Letter of Intent for Monument Glamping Special Use Modification, Fall 2023

Monument Glamping El Paso County, Colorado

PCD File No. AL2321
Prepared: August 11, 2022
Addended: October 26, 2023

MONUMENT GLAMPING SITE PLAN
16315 RICKENBACKER AVE.
MONUMENT, CO 80132

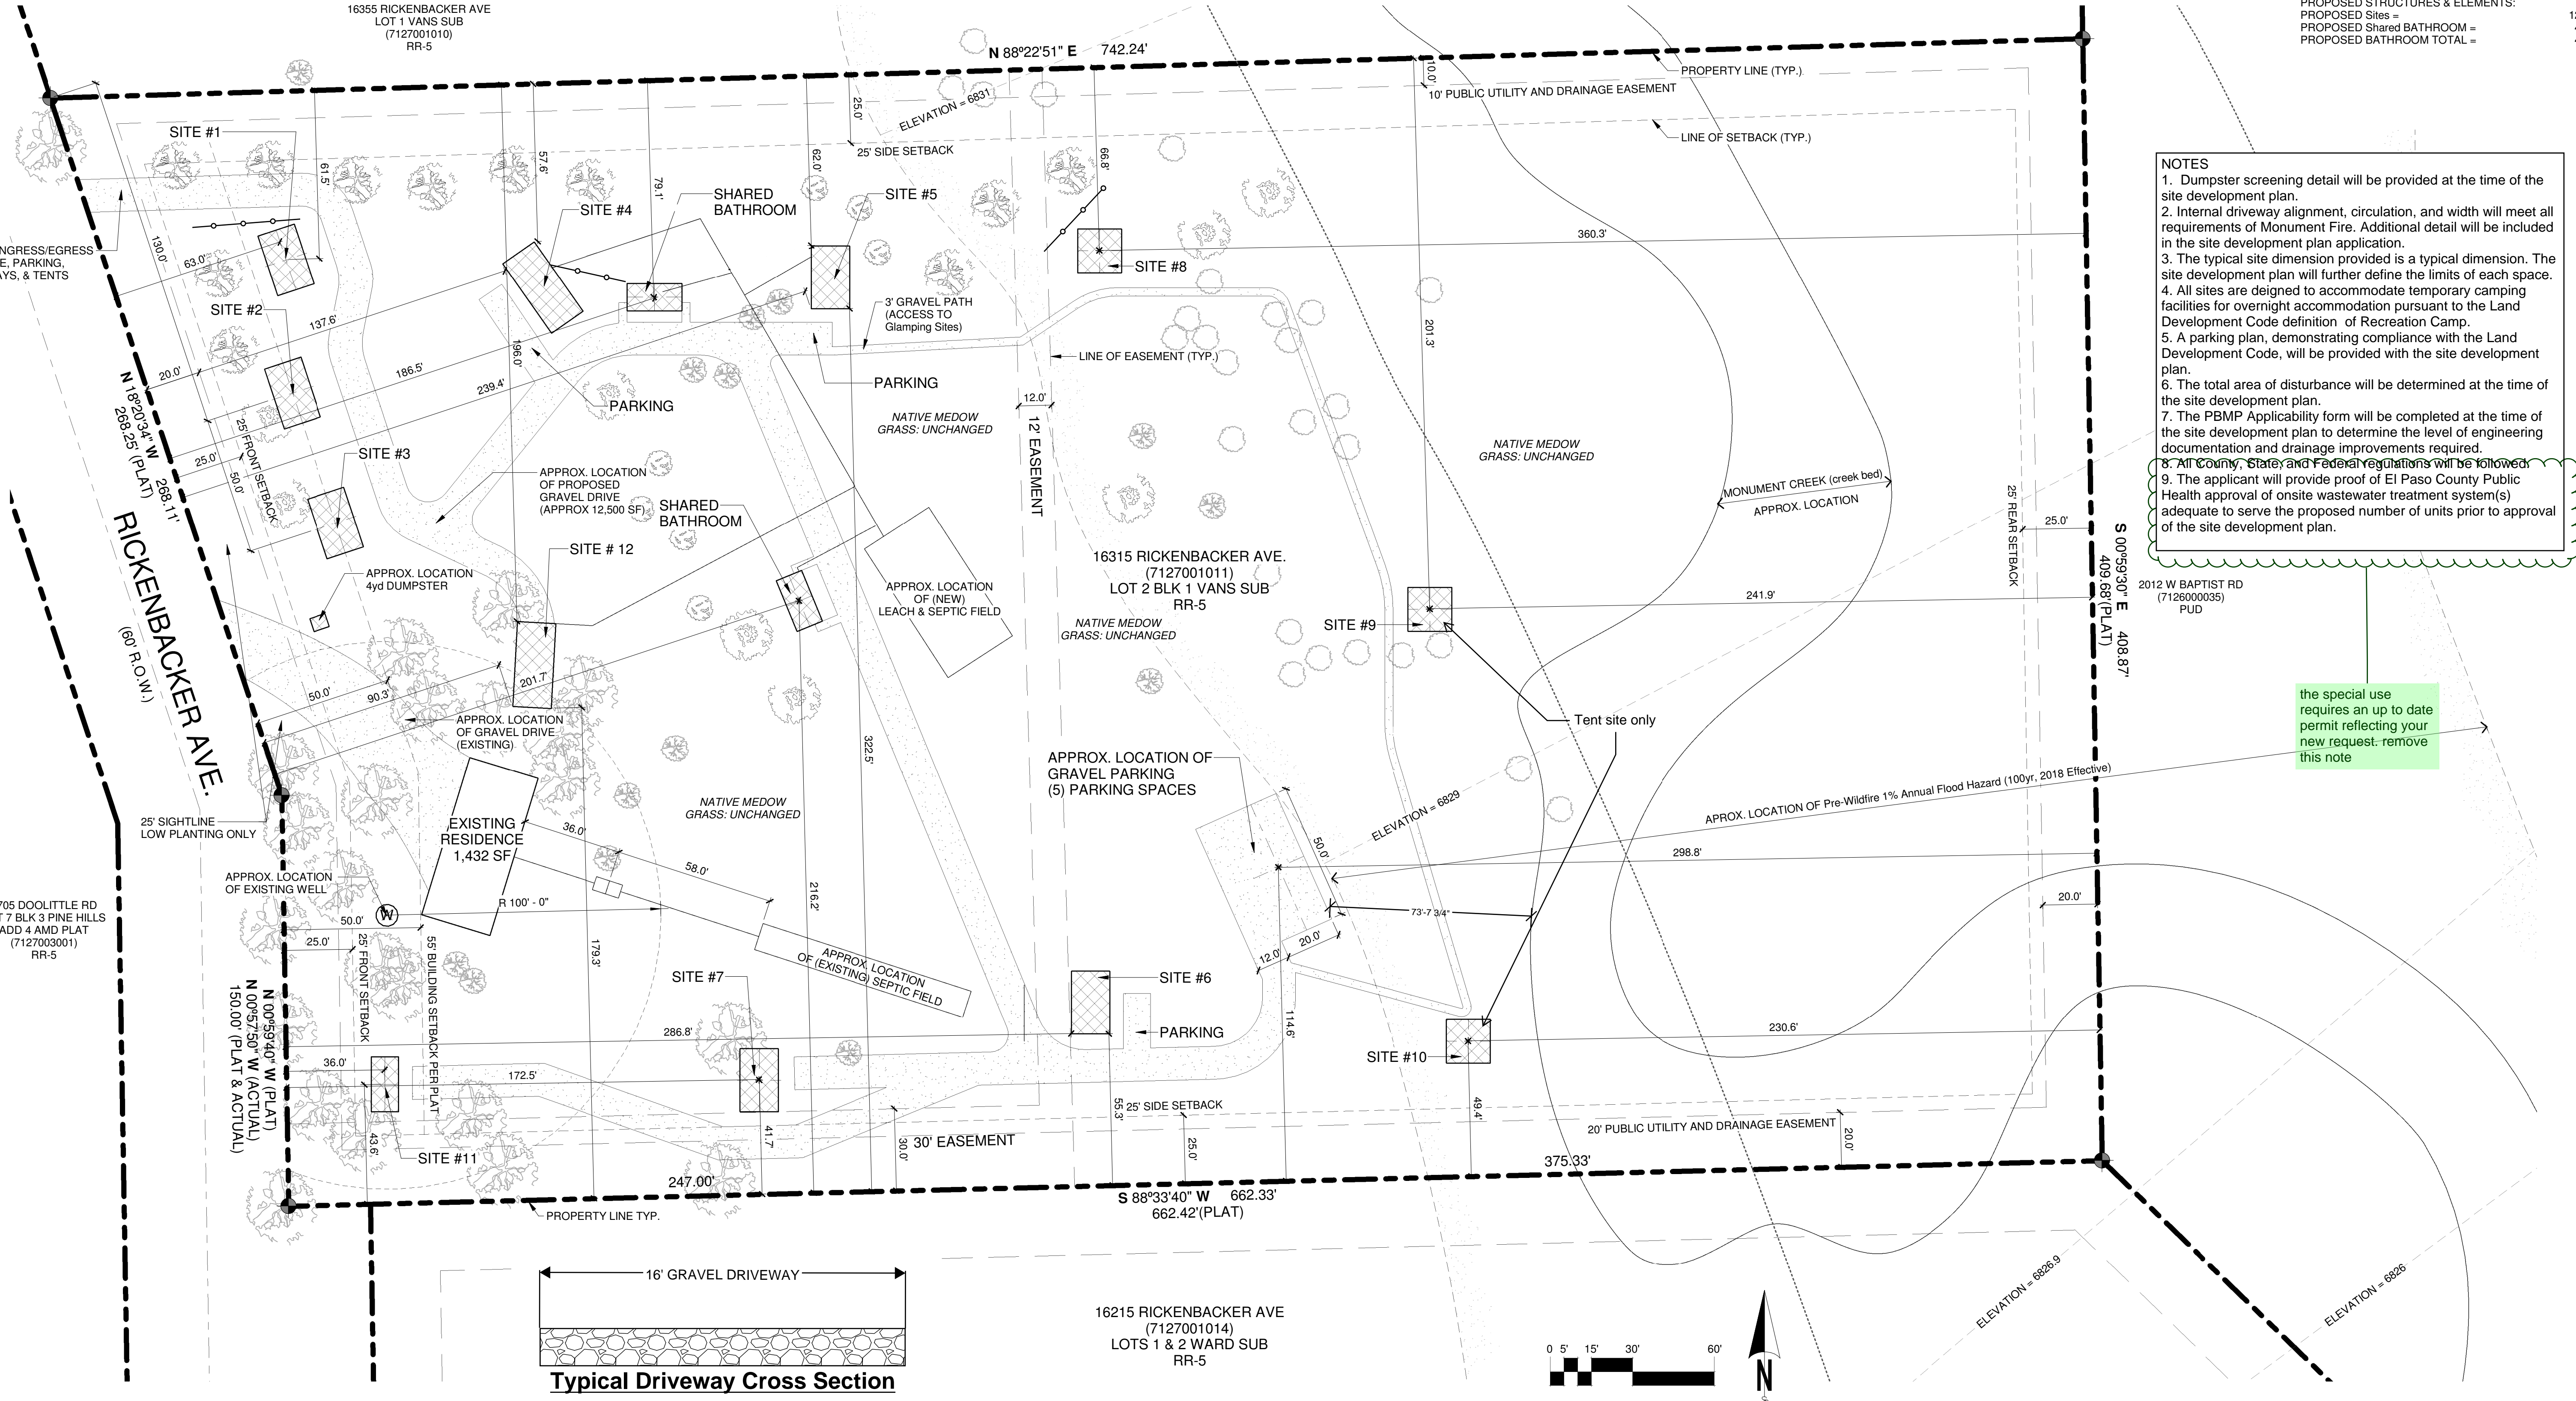
9/26/23 from EPC Code Enforcement: “Unpermitted modified shipping container located at the far southwest corner of the property is not included in the submittal and it is in violation of the required 25ft. setback.”

Response: The modified shipping container has been shown on the site development plan with an explanation that it will be moved to one of the eight approved glamping sites on the property, thus removing the set-back issue.
